STATUTORY PLANNING CONSULTATION RESPONSE

Application Number:	3/2025/0801
Proposal:	Proposed erection of new residential development comprising 80 new homes, including 30% affordable housing, open space and associated infrastructure.
Location:	Land to east of Salesbury View Wilpshire

The Lead Local Flood Authority **maintains its objection** to the above application on the basis of:

Objection 01 – Inadequate Surface Water Sustainable Drainage Strategy

Drawing file: planx_downloads / 25_0801_amended_Schematic_Drainage_Layout_Sheet_2_P13_5jan26.pdf

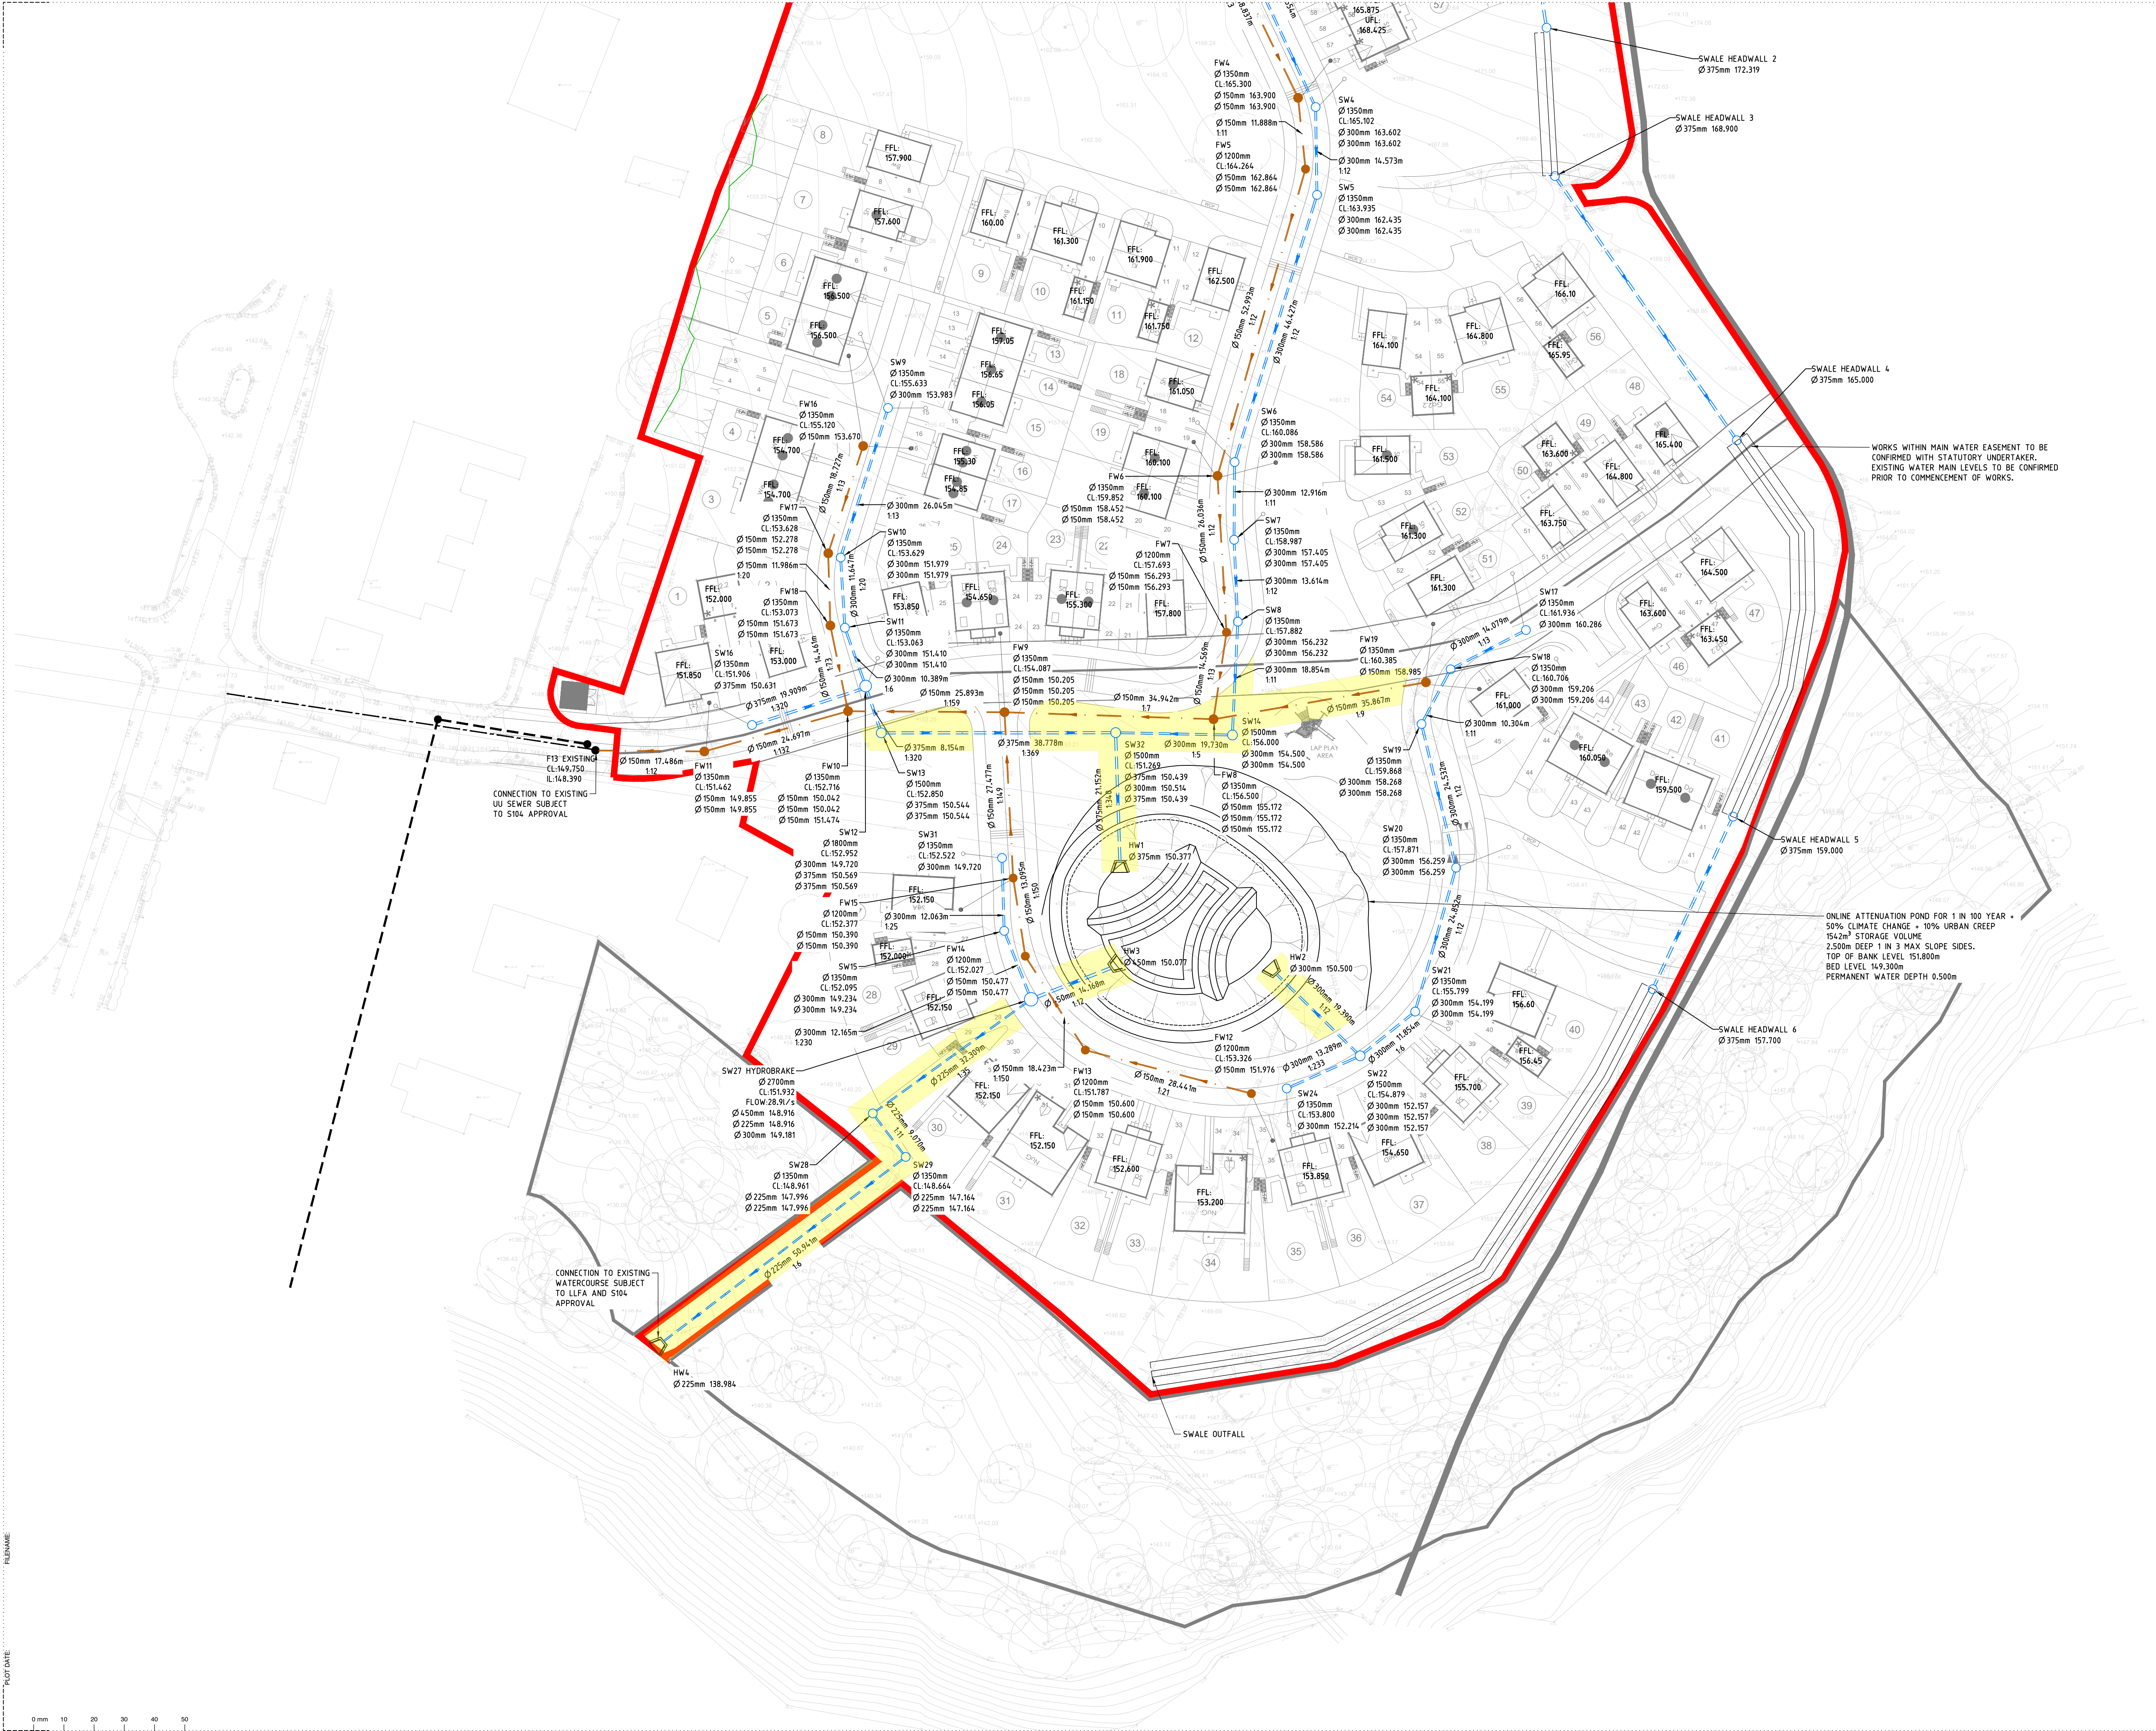
3. **Inconsistent contributing area to size the SuDS** – The proposed drainage strategy fails to demonstrate compliance with Standard 3 of the National Standards for Sustainable Drainage Systems.

The submitted drainage strategy sizes the SuDS and the discharge rate 28.9/s based approximately on a contributing area of 3.327ha only, however the applicant has provided evidence that the proposed contributing area for the development is approximately 1.988ha, in addition to this the applicant has failed to include the proposed attenuation pond as part of the contributing area, and therefore means that the SuDS is potentially undersized.

The applicant must design their SuDS with an appropriate estimation of the area contributing to the drainage system, both permeable and impermeable, with evidence of this area provided through an appropriate contributing area plan, or

otherwise demonstrate how surface water runoff from non-drained areas will be managed without contributing to the drainage system and without increasing flood risk onsite or elsewhere.

- For the avoidance of doubt the applicant has failed to provide any updated information to address objection points 1 and 2 and in regard to point 3, the applicant has failed to provide evidence of a consistent approach to calculating the discharge rate and the required storage volumes, as outlined above. Should the applicant proposing to drain the entire site area then it would be appropriate to propose a discharge rate based on this area and the SuDS based on that rate, however, should this not be the case as evidenced in the catchment plan, then the discharge rate and SuDS should be based on the contributing area. As stated previously the proposed SuDS pond should be incorporated into the contributing area.
